OFFICIAL NOTICE OF DECISION

CITY OF ALBUQUERQUE
PLANNING DEPARTMENT
DEVELOPMENT REVIEW BOARD

Project# 1004233

WESTLAND DEVELOPMENT CO LP request(s) the above action(s) for all or a portion of **STORMCLOUD Unit(s) 1, 2, & 3**, zoned RLT, located on TIERRA PINTADA BLVD NW BETWEEN ARROYO VISTA BLVD NW AND ARKANSAS RD NW containing approximately 107 acre(s). (J-08, 09 & H-08, 09)

SEE SHEET 3 OF 5 FOR CONTINUATION

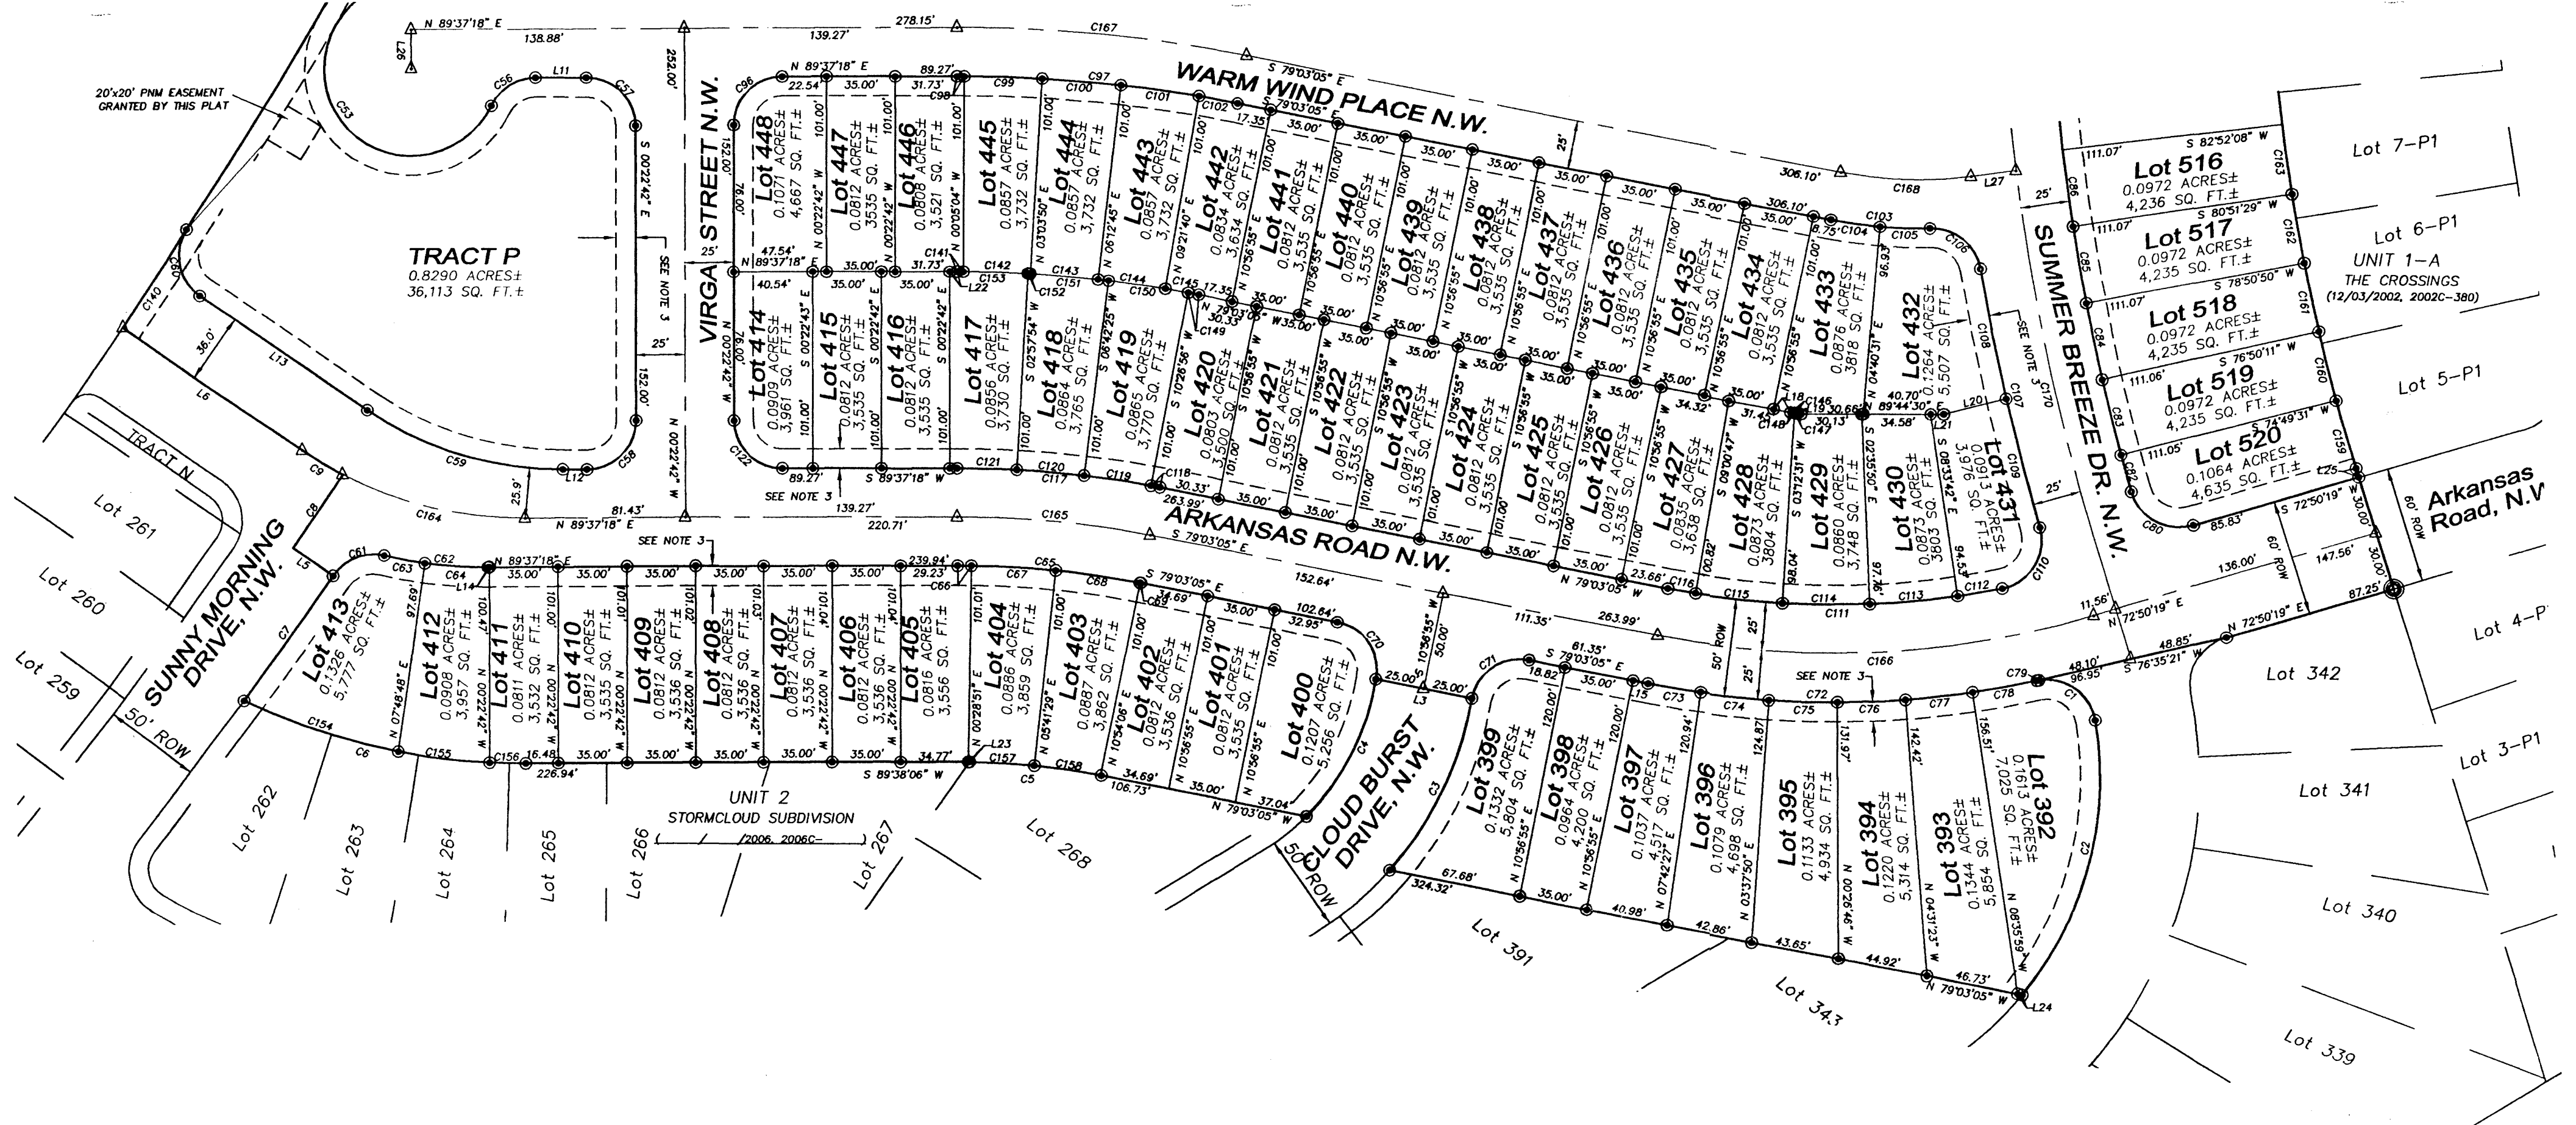
TRANSPORTATION: M: B of tracts
 W, SAS, SD esmt on tract Q
 Master plan study

PLANNING (Last to sign): AMAFCA's Signature
 Record
 StormCloud 2 should be recorded 1st.

AMAFCA must sign plat prior to City Engineer.
Need a storm drain easement on Tract Q.
Provide maintenance and beneficiary information for all tracts.
